From: Thomas Callaway
Sent: 22 July 2015 16:38
To: Planning.Responses
Subject: RE: Planning Consultation on: M/56/15/HH

APPLICATION M/56/15/HH

Site Address: 31 Sea Way Middleton-on-Sea PO22 7RZ

Description of Works: Side & rear extensions

Proposed Floor Plans
- Ground Floor
- First Floor
- Roof Plan

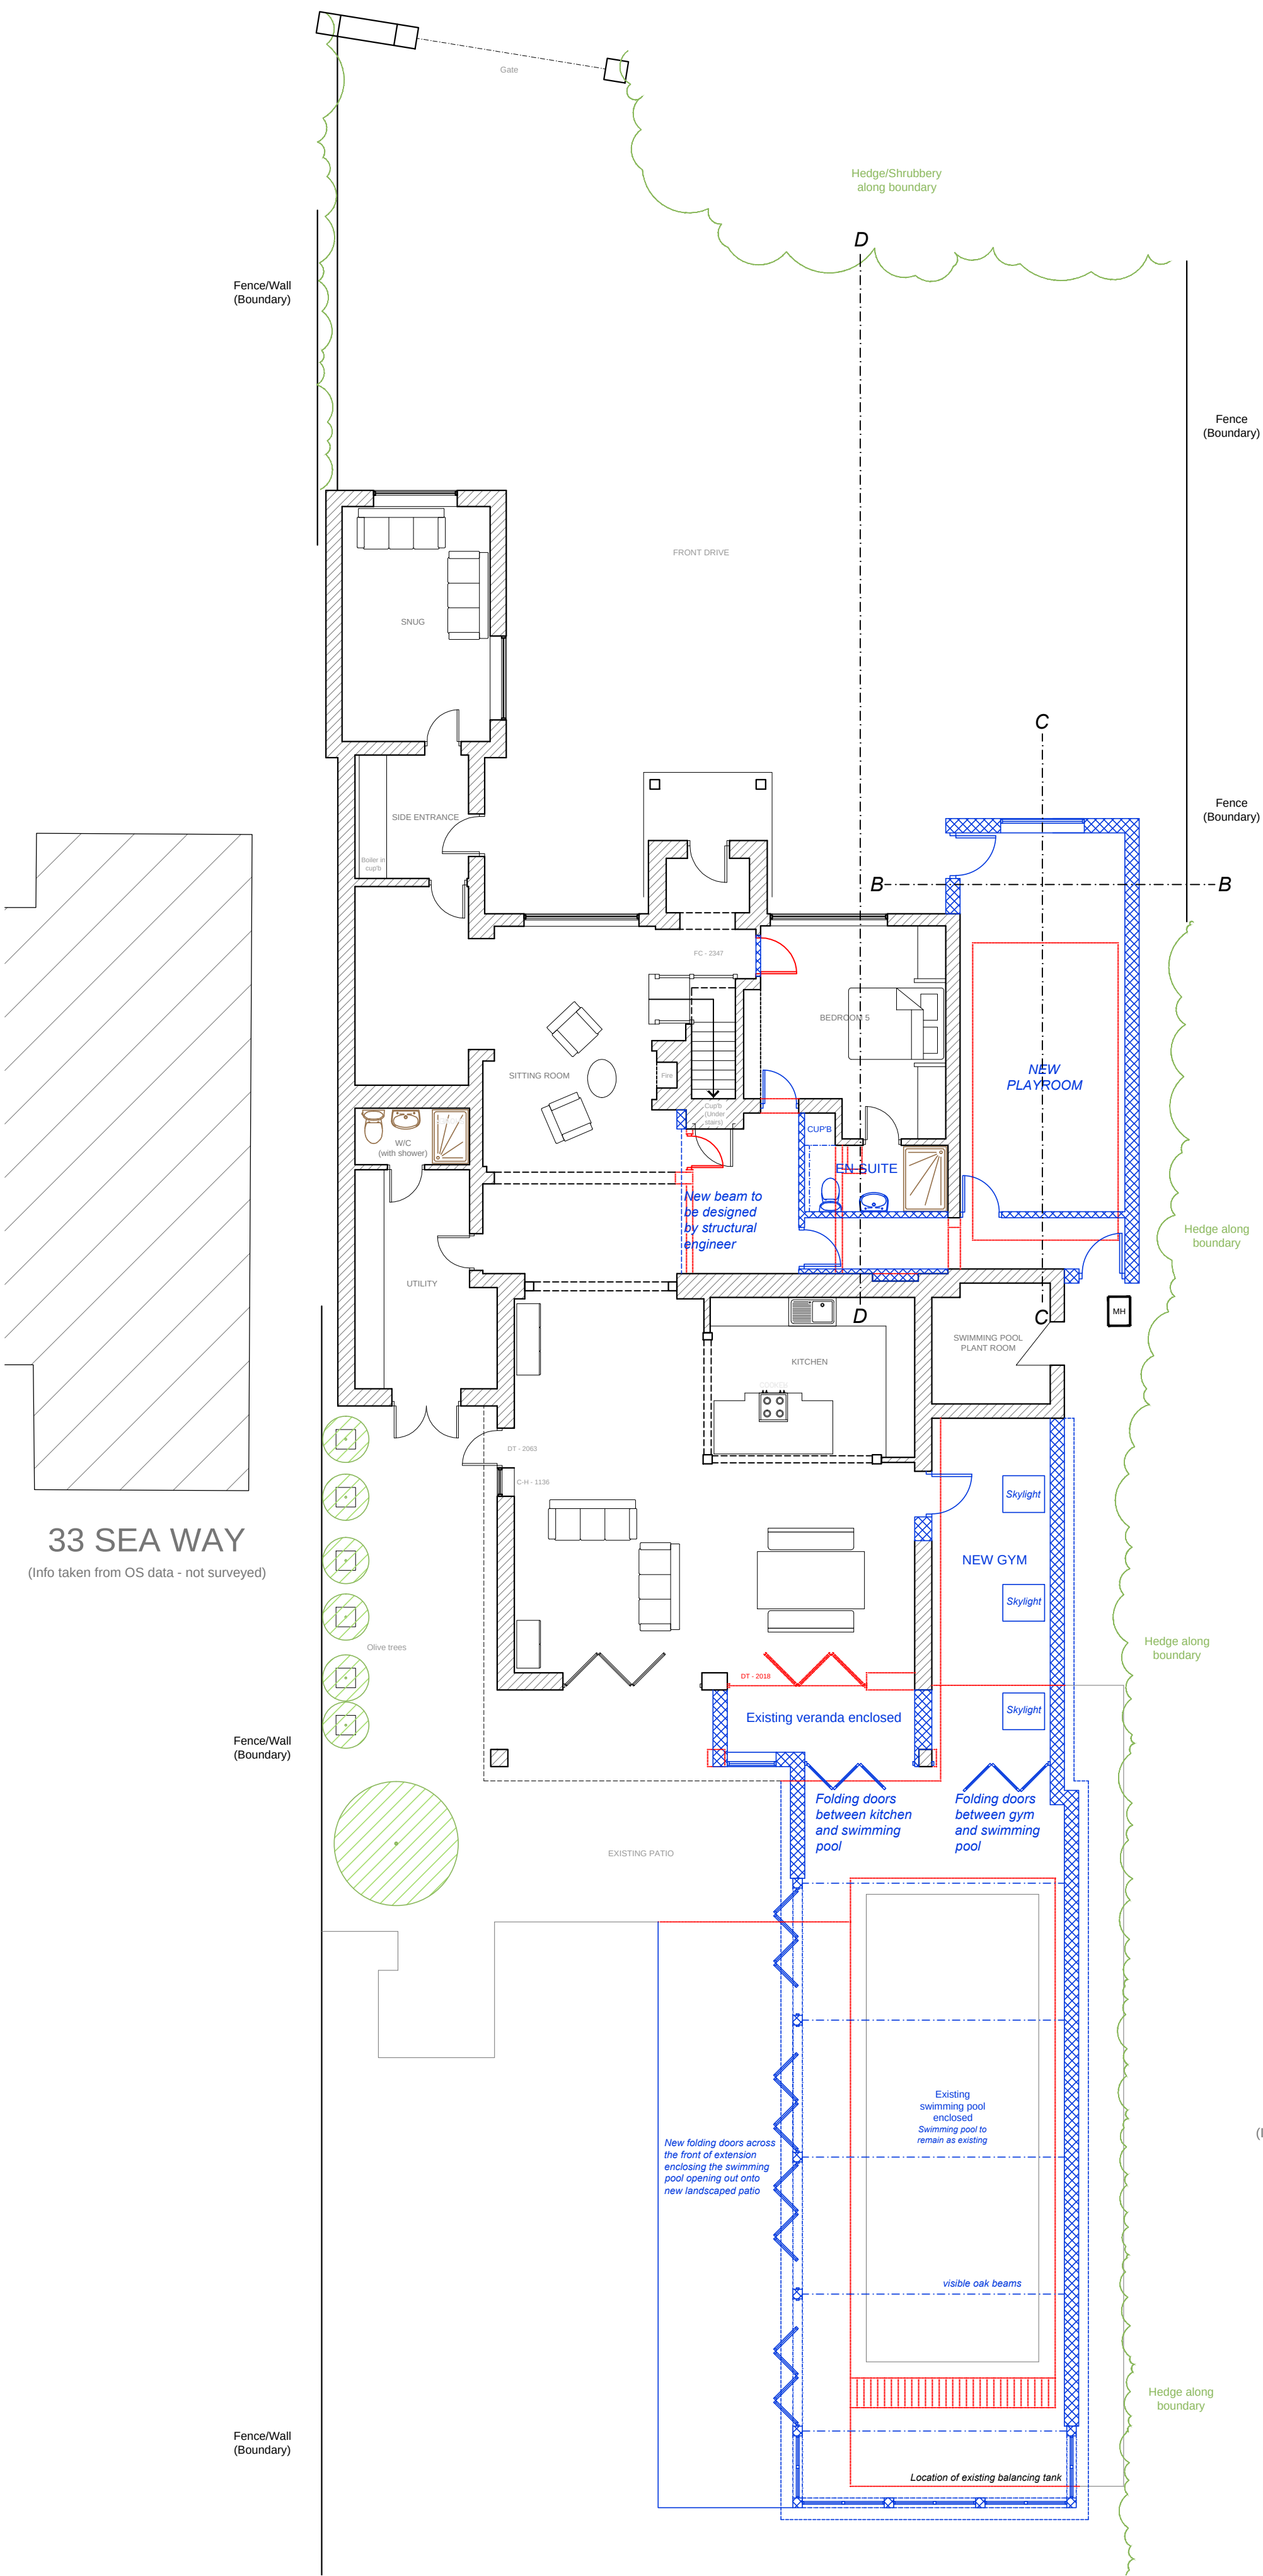
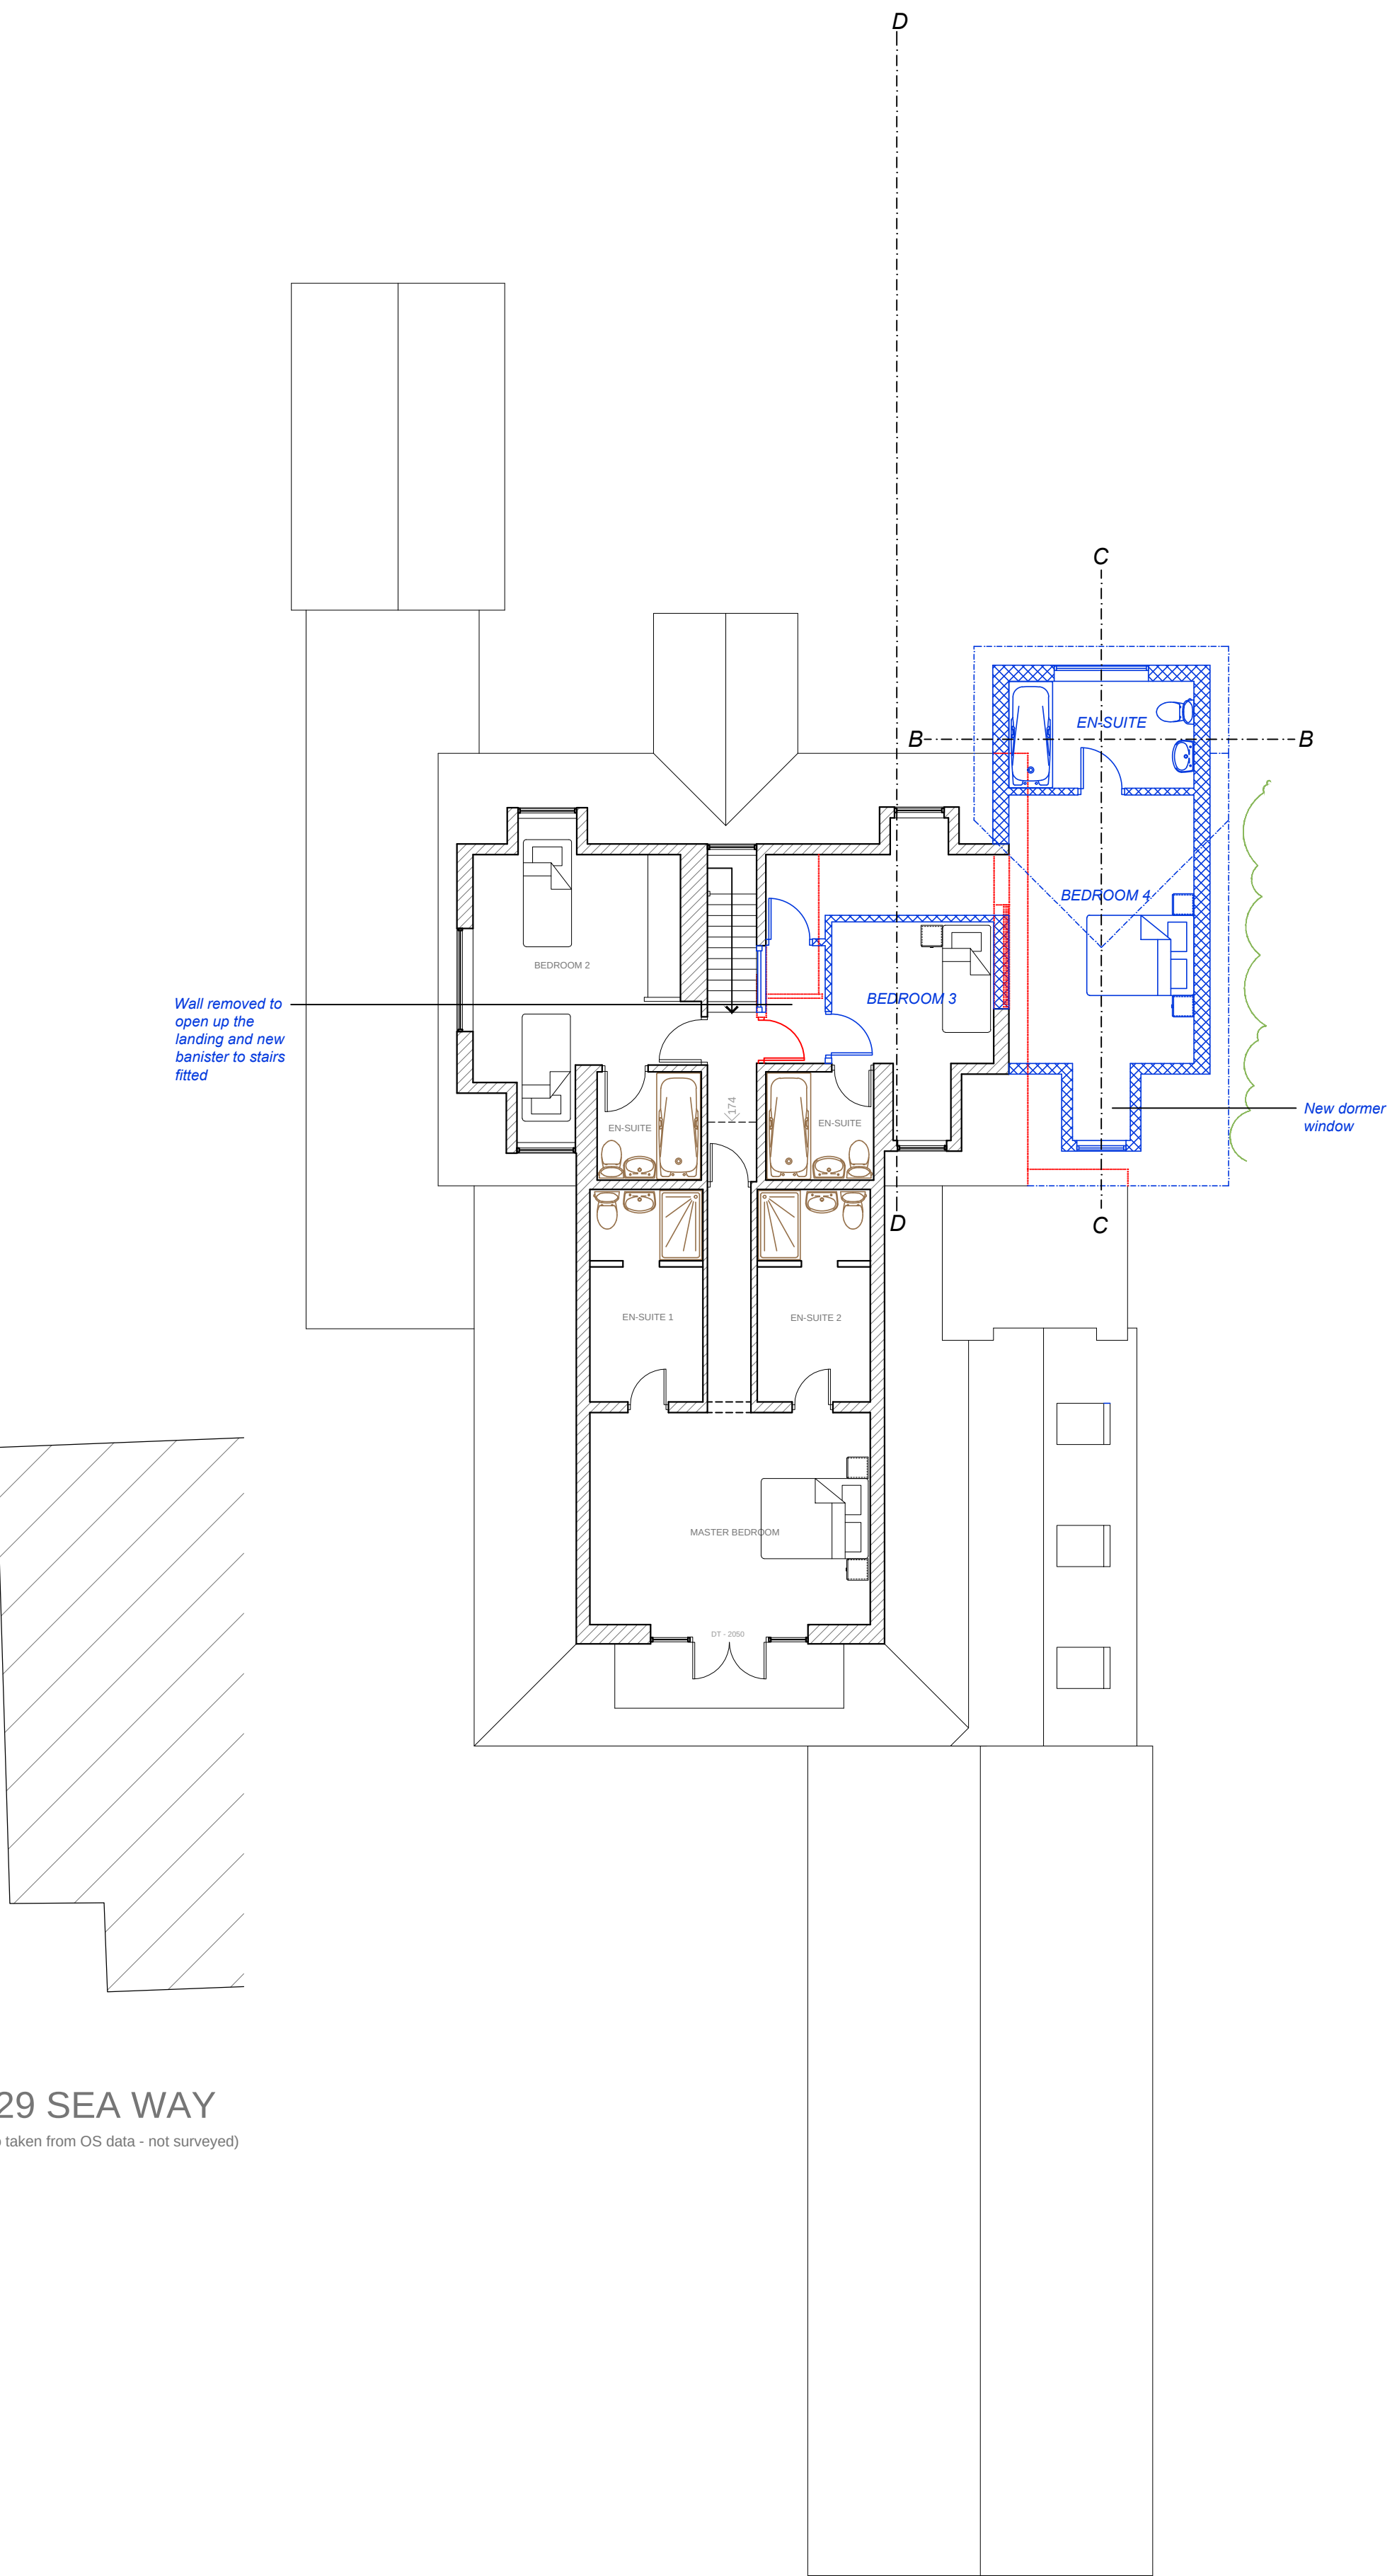
The proposals include building over or close to a culverted watercourse. There should be a three metre easement for access and maintenance of the land drain, which would not be possible if these proposals are approved.

Apply ENGD6A or consider this an objection if layout cannot be altered to suit the requirements of the condition.
